DRAINAGE REPORT for VISTA DEL NORTE, NORTH POND

Re: Las Lomitas Industrial Park Drainage Report Engineer's Stamp dated 1-18-05 (D16/D2)

Las Lomitas Industrial Park Drainage Report Re: Engineer's Stamp dated 11-19-04 (D16/D2)

Las Lomitas Industrial Park

A03JOBS\A3102VNIP\A3102ad.dwg 1-18-05 DER TAS

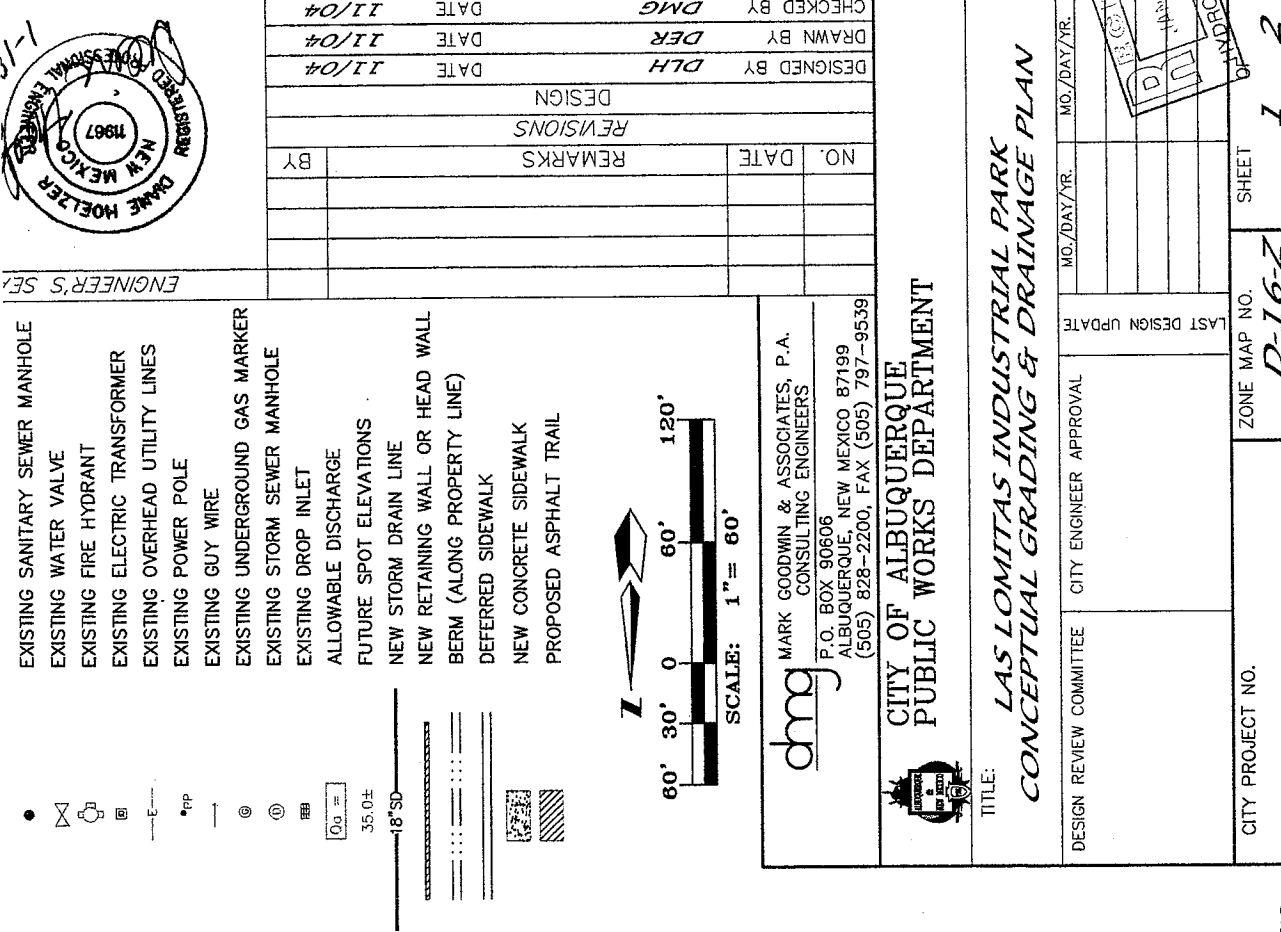
- The berm at Las Lomitas must be entirely on the westernmost lots and no slope should be in the R/W. The maximum slope in the R/W should be 2%.
- Your grading plan shows that the water surface elevation of 5020 encroaches into Tract 5 by at least 25 feet. I would need a public drainage easement to this contour plus 10 feet. It also shows proposed grading of the pond that would keep the pond entirely on Tract U-1. If this were your intent, it would have to appear on your infrastructure list and be done by Work Order.

- Please provide an interim-grading plan showing what you will be grading. This plan should show berms at all property lines.
- Tracts 3-5 are only allowed free discharge if they drain to Las Lomitas. If these lots are proposed to drain to the pond outfall pipe, they must be constrained so as to not exceed the 4.65 cfs allowable. Lots 1 and 2 must likewise be constrained (0.15 cfs per your report). Your AHYMO output must show this.

- Please provide calculations that the 36" pipe can drain your site as well as Tract T-4. From the as-built of Las Lomitas provided, you were only expecting 97.5 cfs in the 48" and now it supposed to handle 150 cfs. Please provide a new HGL analysis of this storm drain.

- Please quantify the existing offsite flow from Tract T-4 or any other source.
